**Sikh Grammar School Rouse Hill  
SSD 9472**

Thank you for your correspondence via ePlanning portal (ref: PAE-730) on 14 October 2019 requesting Transport for NSW (TfNSW) to review and comment on the subject State Significant Development (SSD 9472) Application.

## **TAB A – Detailed Comments on State Significant Application SSD 9472**

Figure 6 – Proposed Bus Corridors Near Development Site

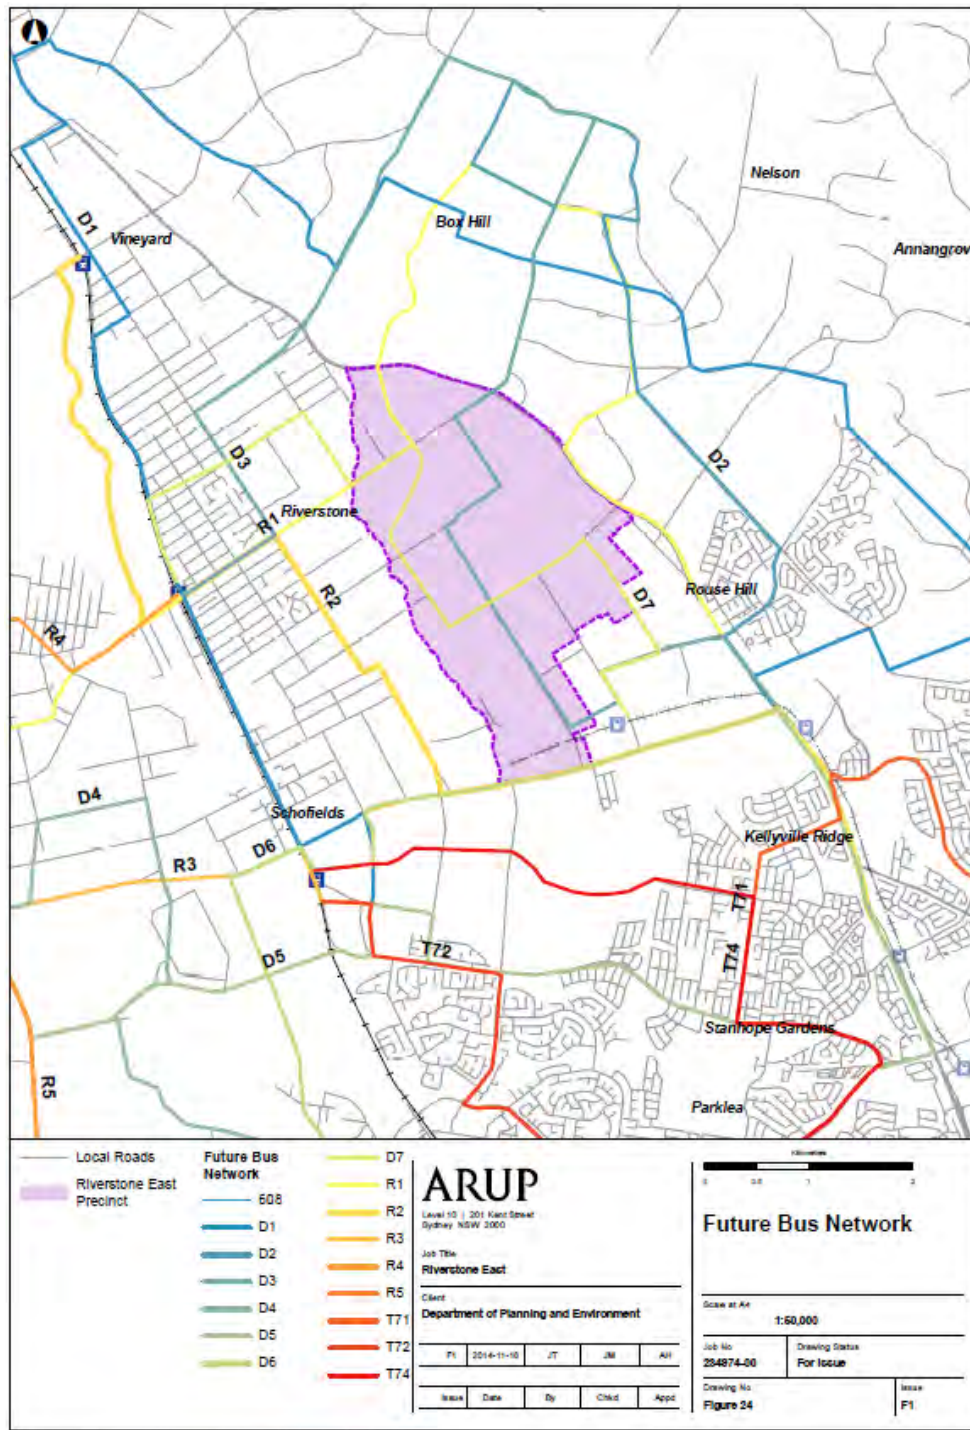
Section 3.1.3 refers to a Bus Servicing Plan which was prepared in 2012 showing an indicative future bus network. While the plan is becoming increasingly out of date with current bus route developments, the ideas continue to be considered as part of current planning work. Route 742 currently operates along Tallawong Road past the subject site linking Riverstone Station with Rouse Hill Station via Tallawong Station.

Prior to the commencement of school operations, the proponent should provide additional data and the proposed student catchment area to determine the likely demands on the transport network (all modes). With particular regard to bus usage, data should also be provided on existing and expected patronage by route. This data could be obtained by travel surveys of staff and students.
